35 Industrial Way

Please see the responses below to the review questions.

SHEET TITLE:
FIRST FLOOR PLAN

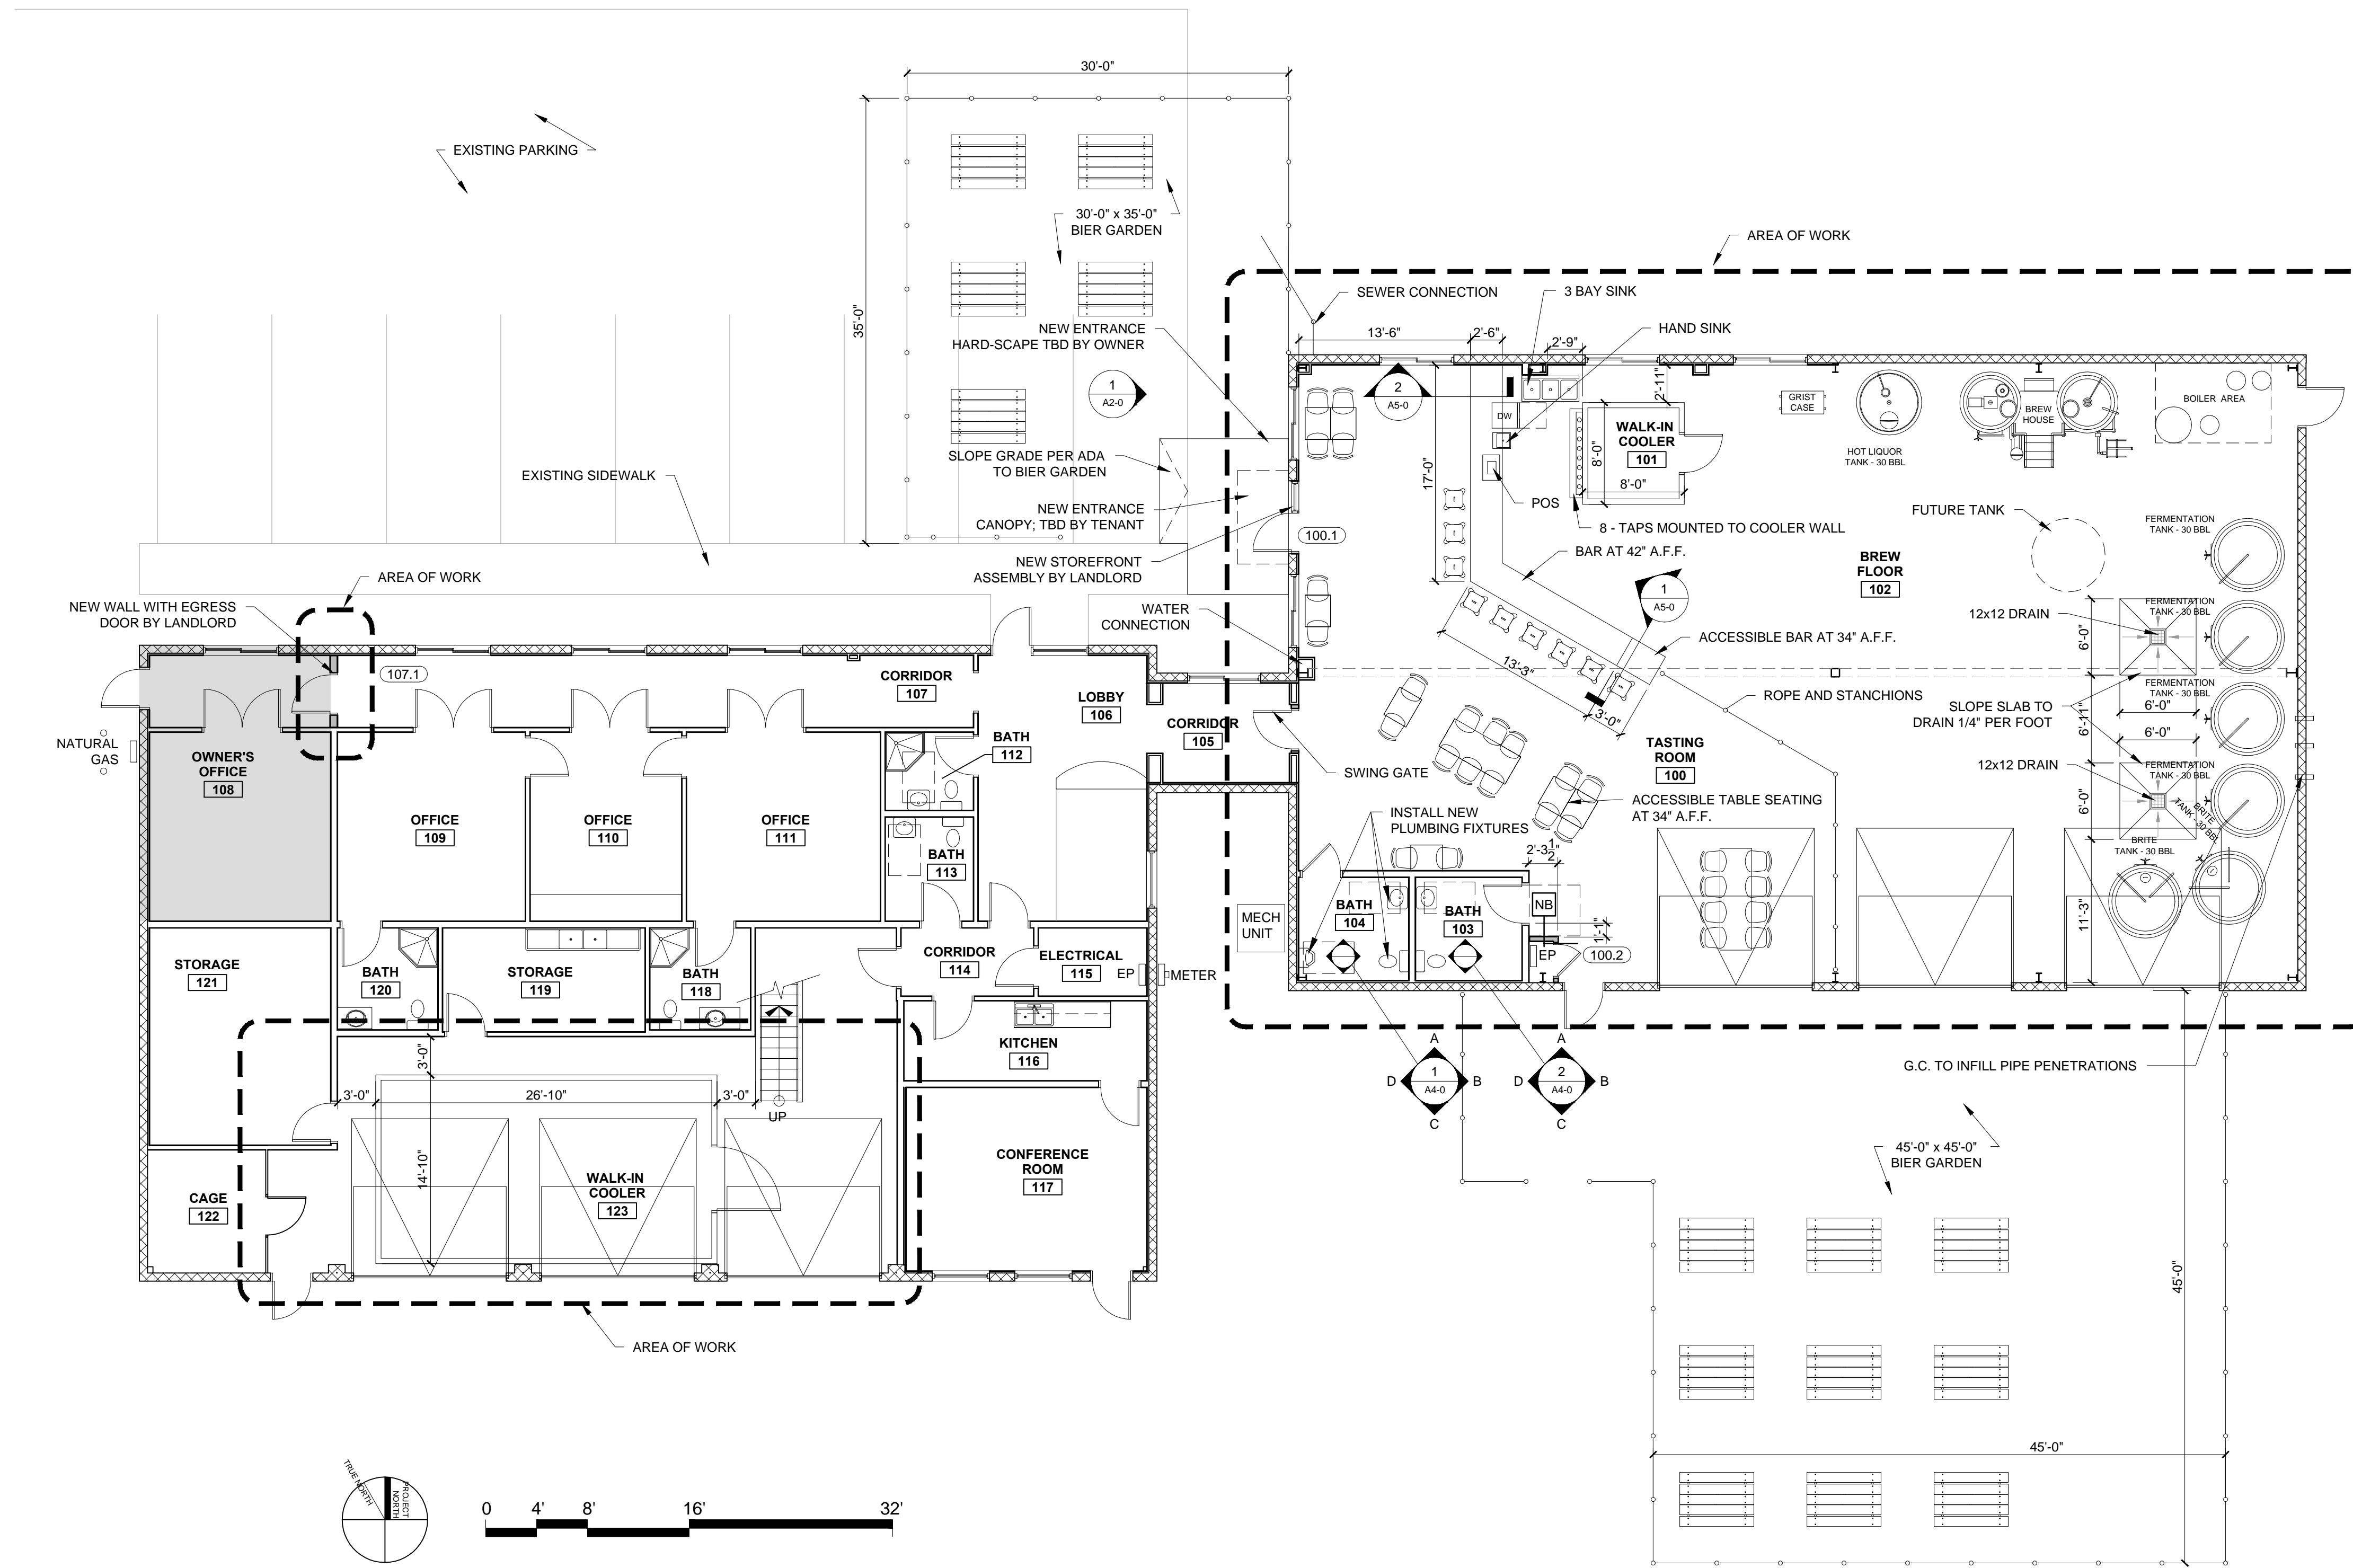
- 6.) The 2 doors indicated on the plan to be provided by landlord will be submitted by the landlord under a separate building permit from this tenant fit-up permit.
